About the application

Application number: 2023/90349	
What is the application for?:	Erection of detached dwelling
Address of the site or building:	adj, 11, Park View, Cleckheaton, BD19 3AN
Postcode:	BD19 3AN

Proposed:  
Floor Plans  
Elevations

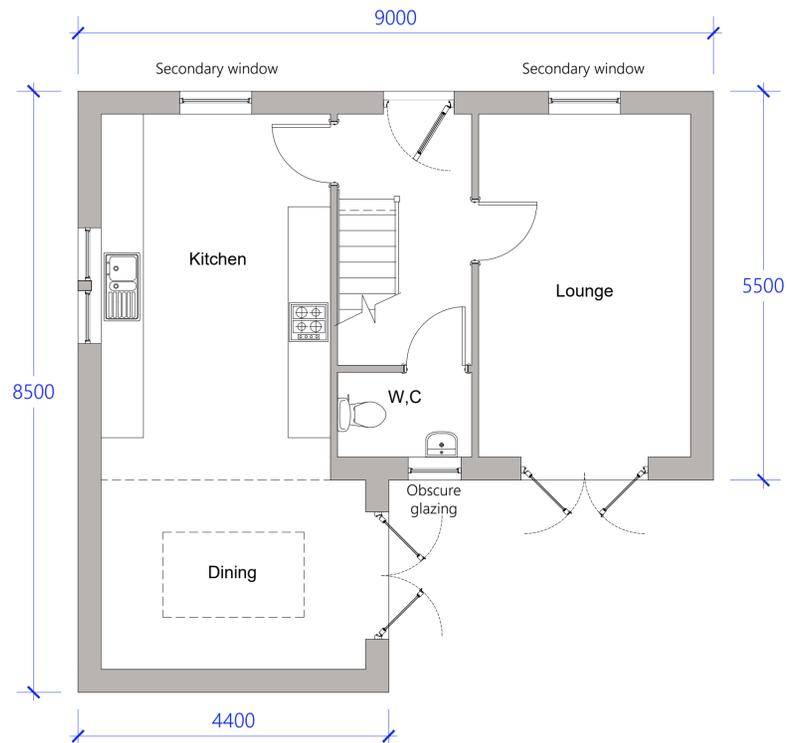
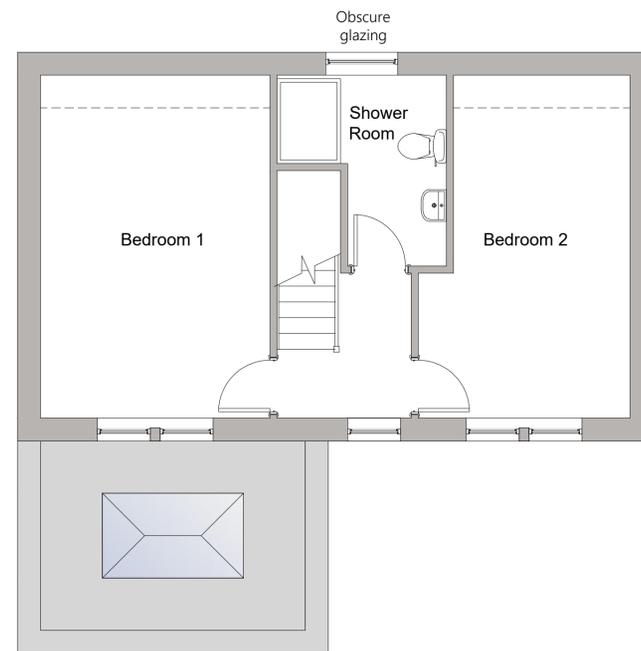
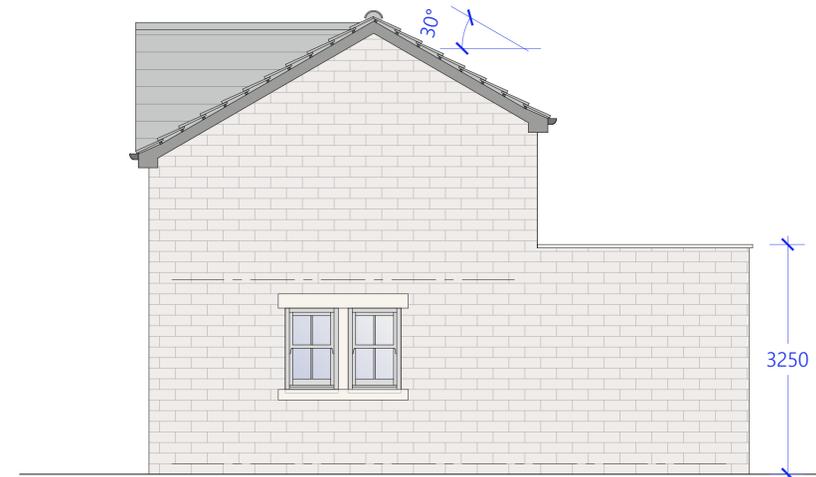
Type of comment: An objection	
Do you wish your comments to be published on the website anonymously?	Yes
Permission has already been refused 3 times for a detached dwelling on this land, I personally don't see how/ why this is any different to previous proposals. This proposal is not in keeping with the houses surrounding it. It will overlook several existing dwellings and will cause more parking issues on an already crowded street.
